Derby Cycling Group,  
[REDACTED]  
[REDACTED]  
[REDACTED]  
[REDACTED]

Ref: **A38 Derby Junctions – Issue Specific Hearing Wed 19<sup>th</sup> February, 2020**  
**Deadline 6 submission by Derby Cycling Group**

Prior to attending the Issue Specific Hearing on 19<sup>th</sup> February 2020, Derby Cycling Group reviewed the new issue of the A38 Derby Junctions Traffic Management Plan (issue 7.4a) against suggested amendments we had made as part of our Deadline 3 written submission, following the Issue Specific Hearing on 11<sup>th</sup> December 2019.

Drawing Title  
FIGURE 2.6  
MARKEATON JUNCTION  
GENERAL ARRANGEMENT

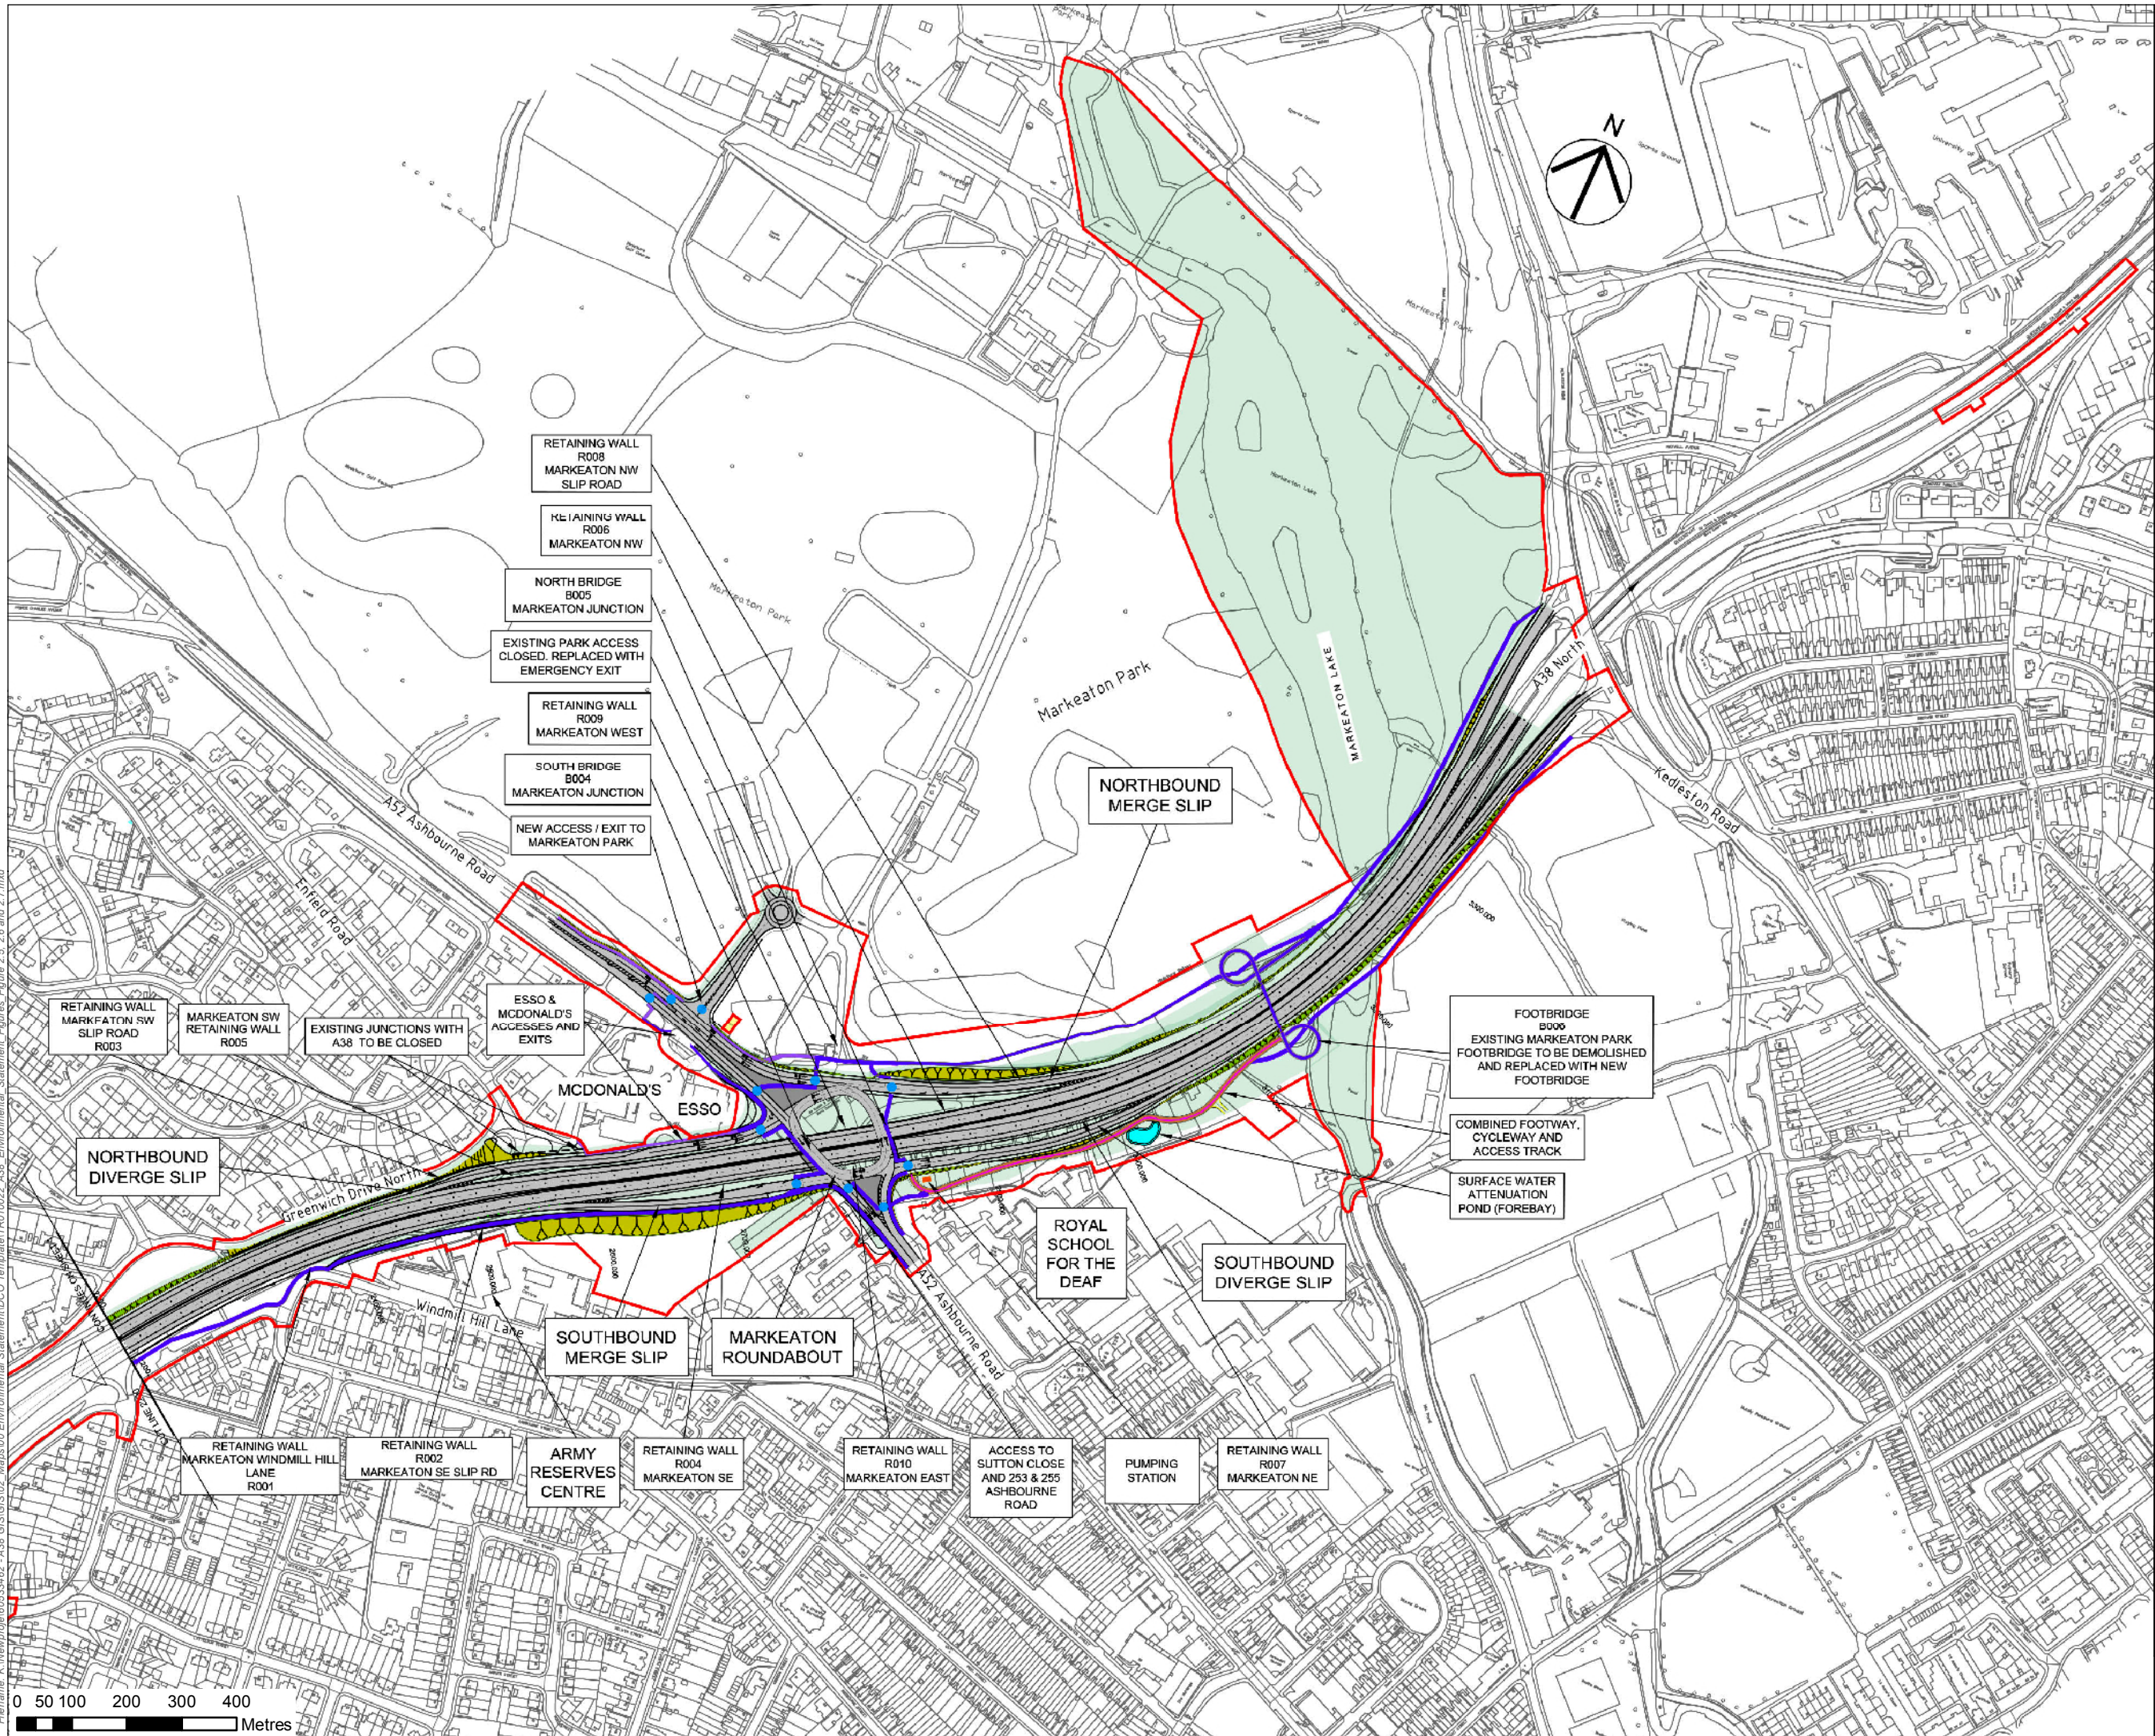
- Some specific places would be the A52 across the face of the Esso/Macdonalds entrances, to access the A38 crossings leading to Ashbourne Road and Queensway from Mackworth; also the western side of Queensway, which may at times be preferable to the existing paths on the eastern side. There could be other suitable locations as well.

Drawing Title  
FIGURE 2.7  
LITTLE EATON JUNCTION  
GENERAL ARRANGEMENT

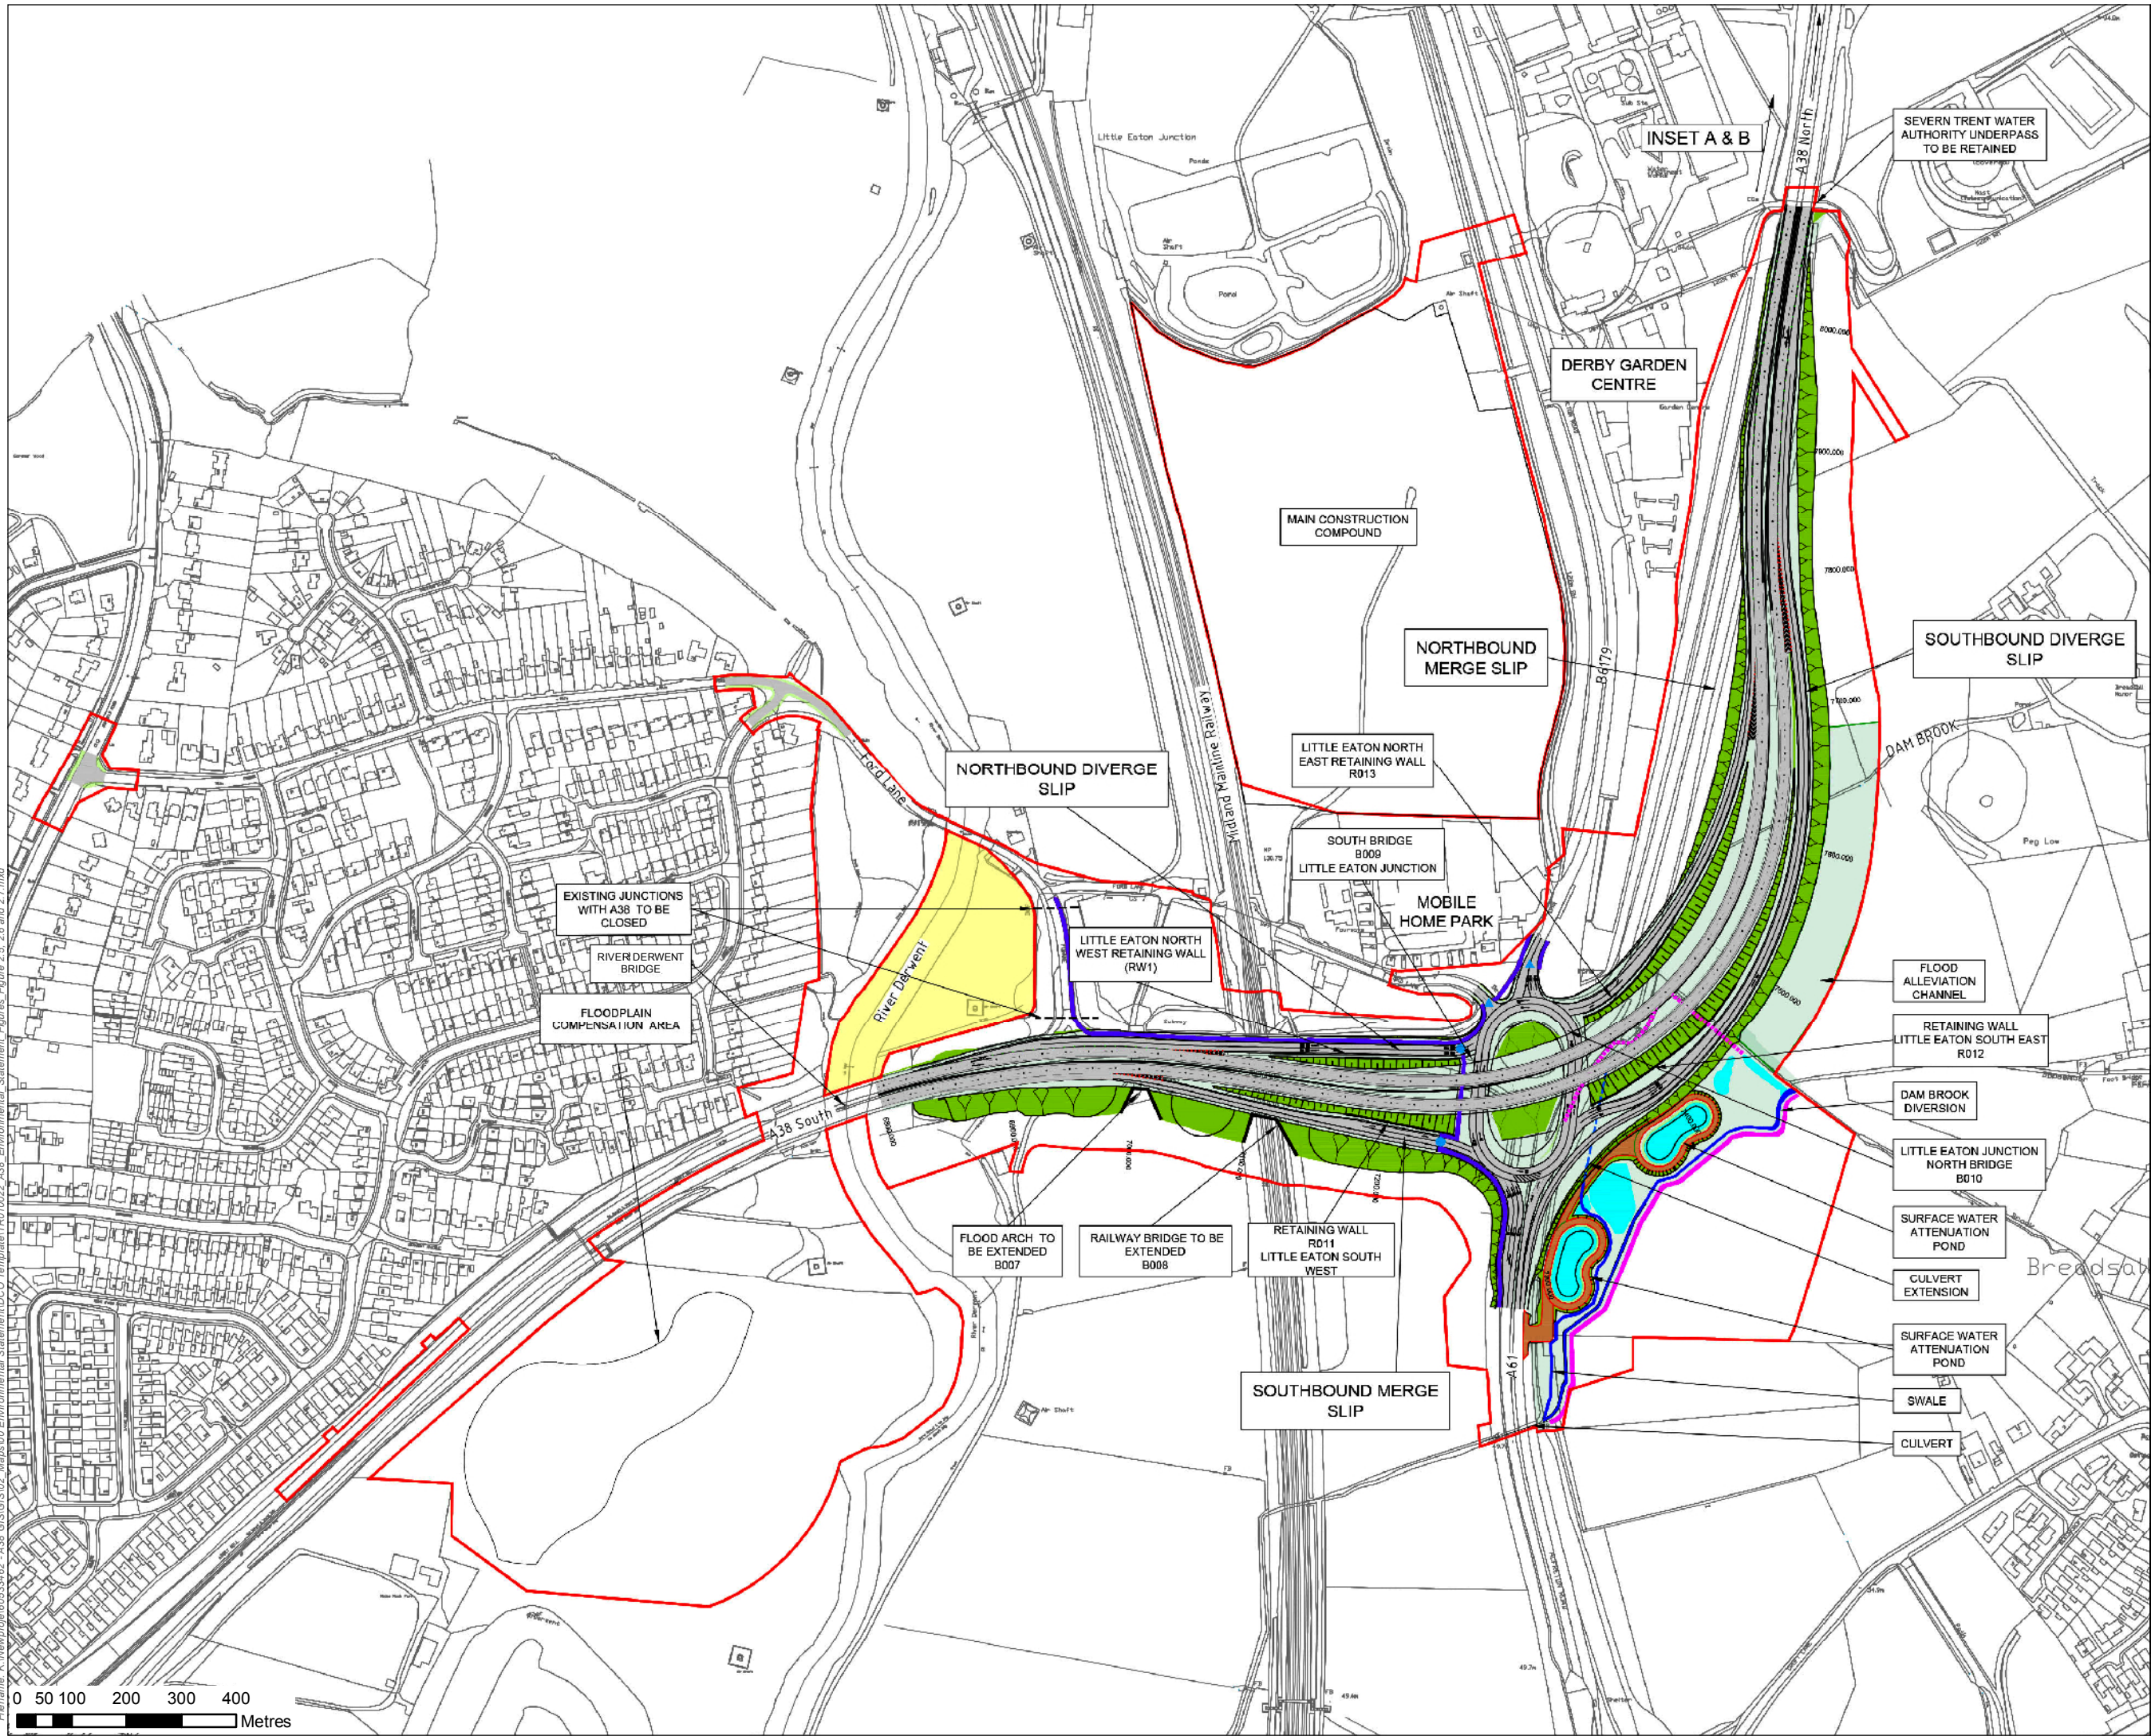
Derby Cycling Group would like to reiterate our total support for the controlled cycle/pedestrian crossing over the A61 between Pektron and Little Eaton islands. This crossing will facilitate significantly more cycling to and from Breadsall village and beyond, heading towards Derby City and Little Eaton. We regard the inclusion of this crossing as a matter which is independent of the issues under discussion regarding the re-routing of footpath 3 (FP3)
